18 December 2014

Our Ref: SE/CL/2014/38175/N

**App Ref:** 14/01932/OUT  
**Site:** OS Parcel 7400 Adjoining And South Of Salt Way Banbury  
**Proposal:** Outline - Development of up to 1,000 dwellings together with a mixed use local centre. [including A1 retail up to 1,000 m2, financial services (A2), restaurants, pubs and takeaways (A3, A4, A5), community uses (D1)]; primary school; green infrastructure including formal (including playing fields) and informal open space, landscape and amenity space; changing and sports facilities (including D2); sustainable drainage systems; highway, cycle and pedestrian routes; car parking; infrastructure (including utilities); engineering works including ground remodelling; demolition, site reclamation and removal of structures; and the formation of a new access from the A361, Bloxham Road.

Appendix 2: Revised  
Development Framework Plan  
JJG043 / 035 / Rev P

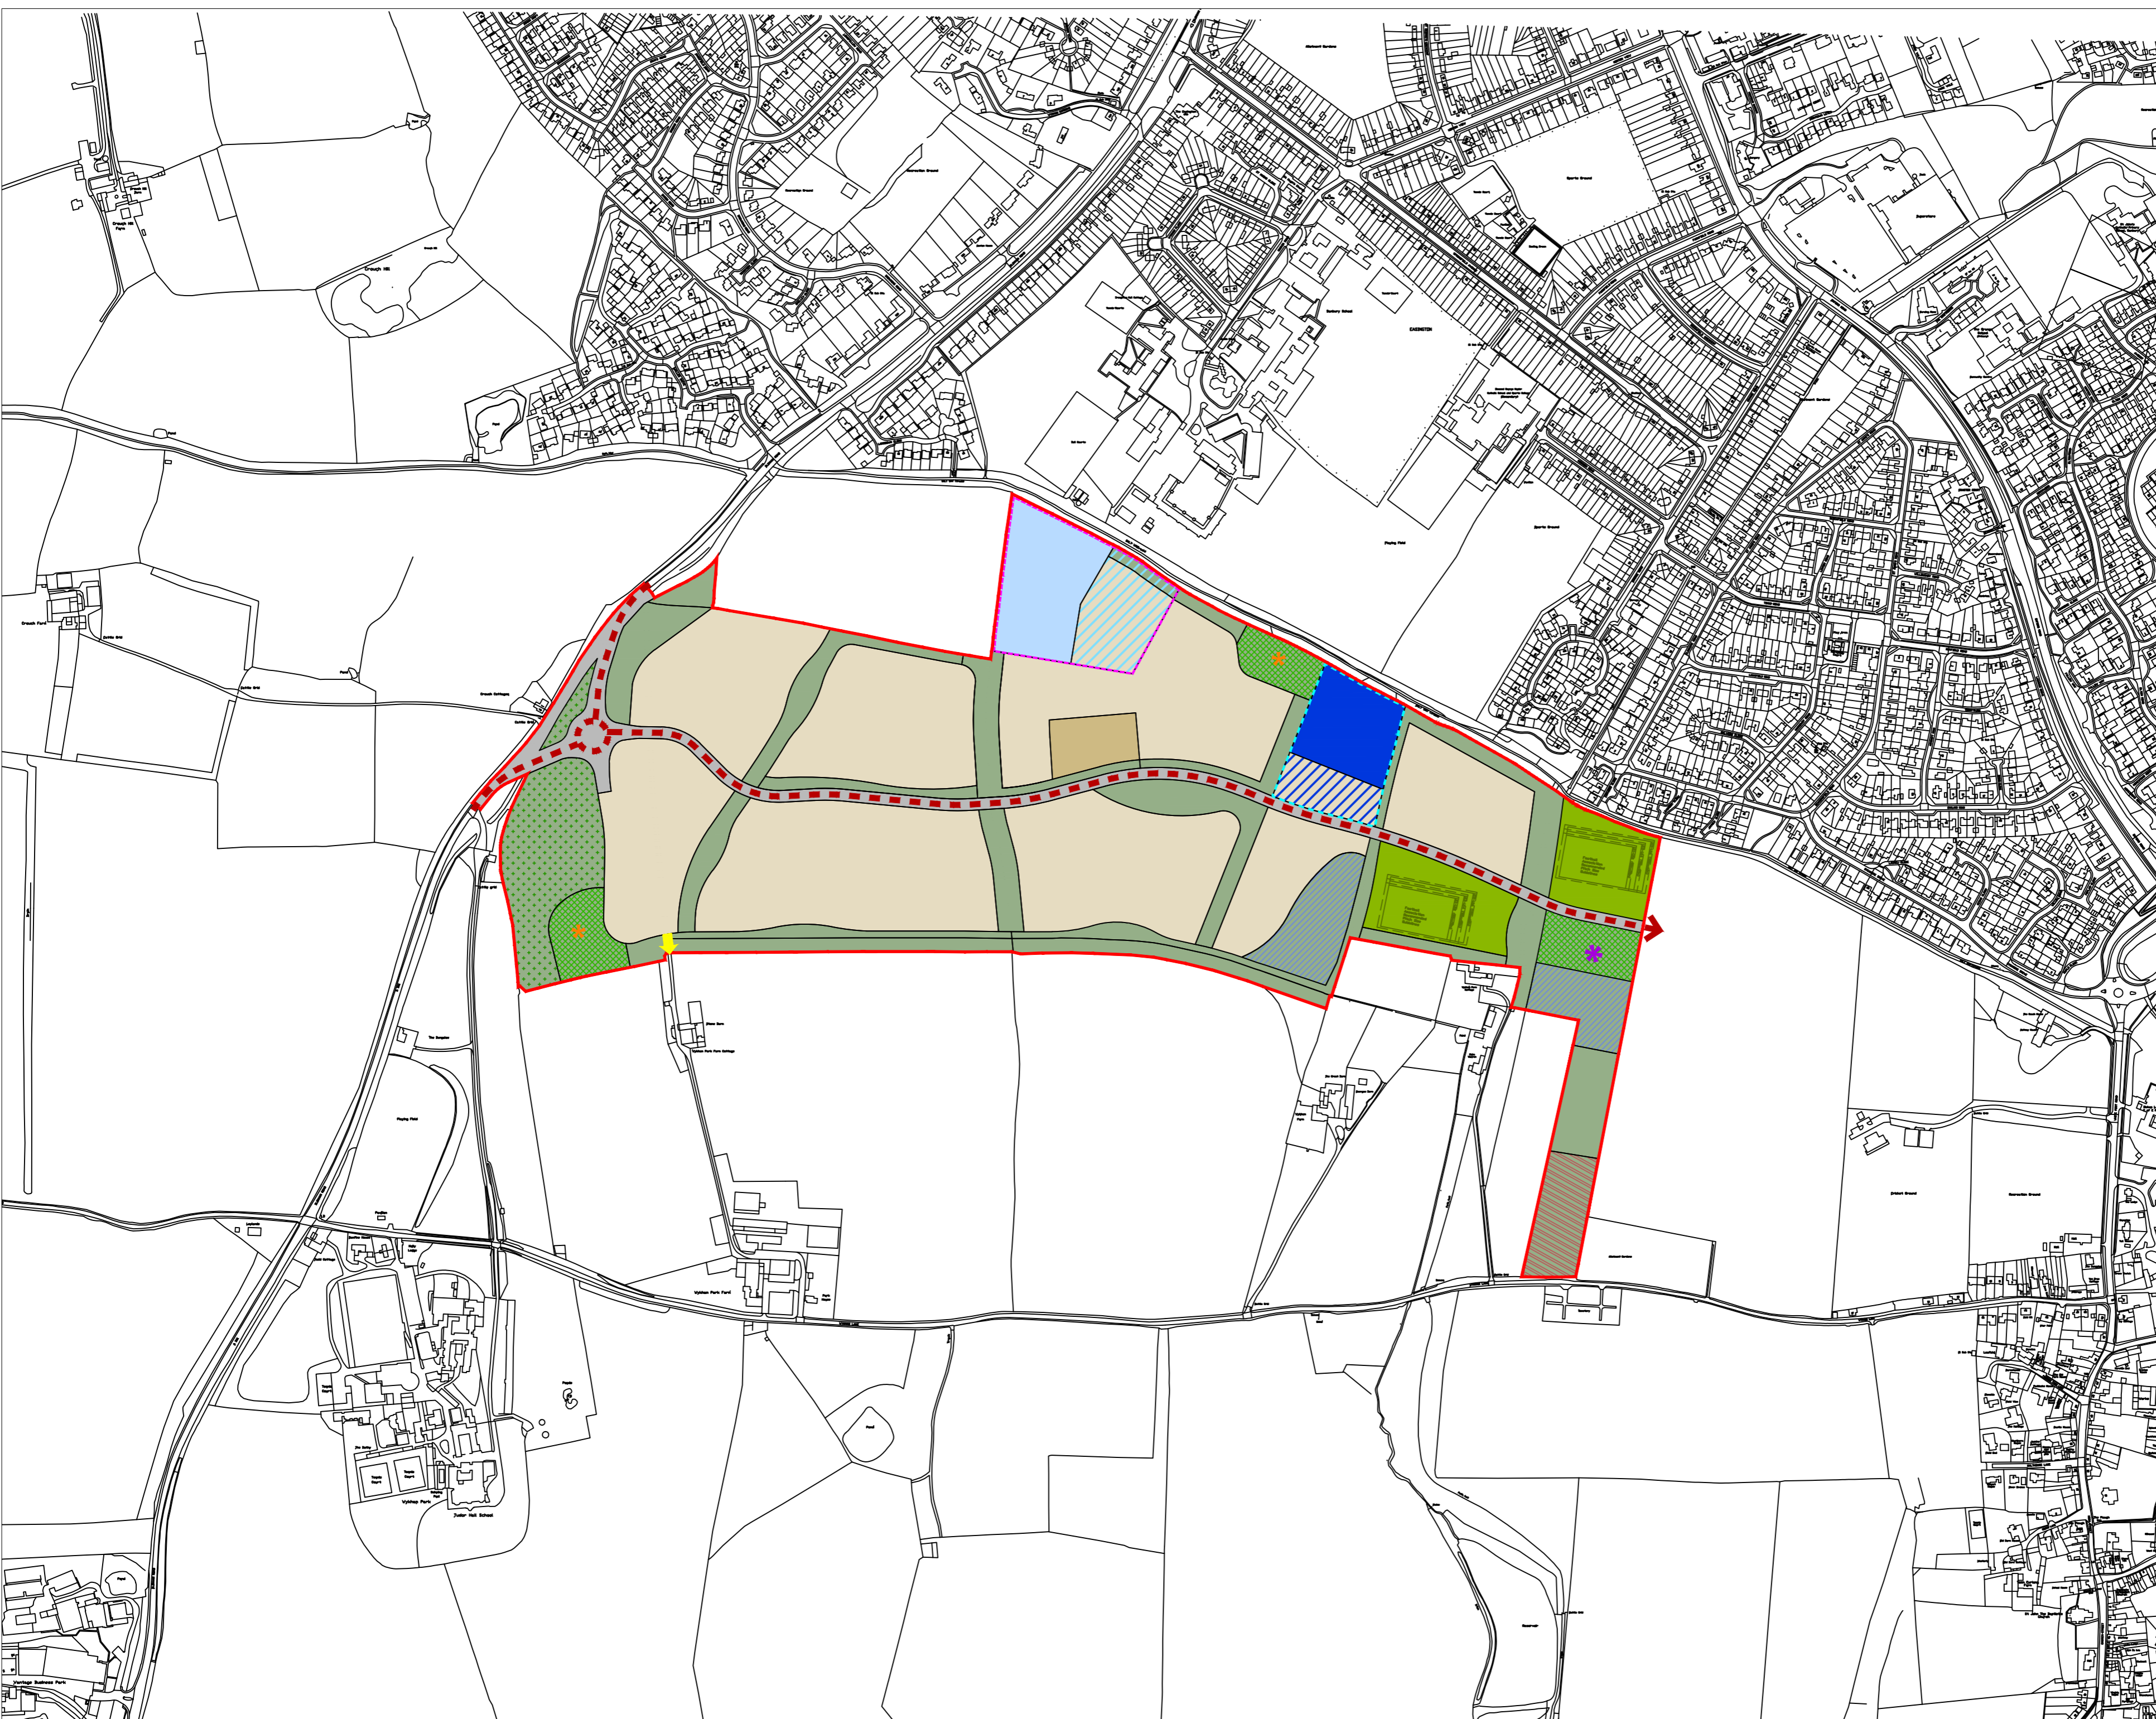
The application is accompanied by a Development Framework Plan (drawing numbered JJG043 – 035) which shows the provision of 2.72ha of land for outdoor sports in two separate parcels in the north-eastern corner of the site. These are separated by an existing tree-lined public footpath and bridleway and by the proposed central spine road/east-west link to the adjoining land to the east. The submitted Planning Statement makes reference to “...potential opportunities for an element of changing facilities...” (Paragraph 3.36) and also anticipates the inclusion of a Multi-Use Games Area within a Neighbourhood Equipped Area for Play on an adjacent part of the site (paragraph 3.37). Planning obligations, set out at the end of the statement, include the provision of these areas together with an appropriate maintenance regime and “To make provision as appropriate and justified for additional community facilities and/or the enhancement of existing or proposed facilities”.

2. While the precise layout of the development will be determined at the reserved matters stage, “Key layout principles are embedded within the Development Framework Plan” (Design and Access Statement, Paragraph 5.26). The provision of outdoor sport on two single pitch sites, separated by existing vegetation and potentially the main route through the site, will be difficult to manage and maintain and is unlikely to be sustainable.
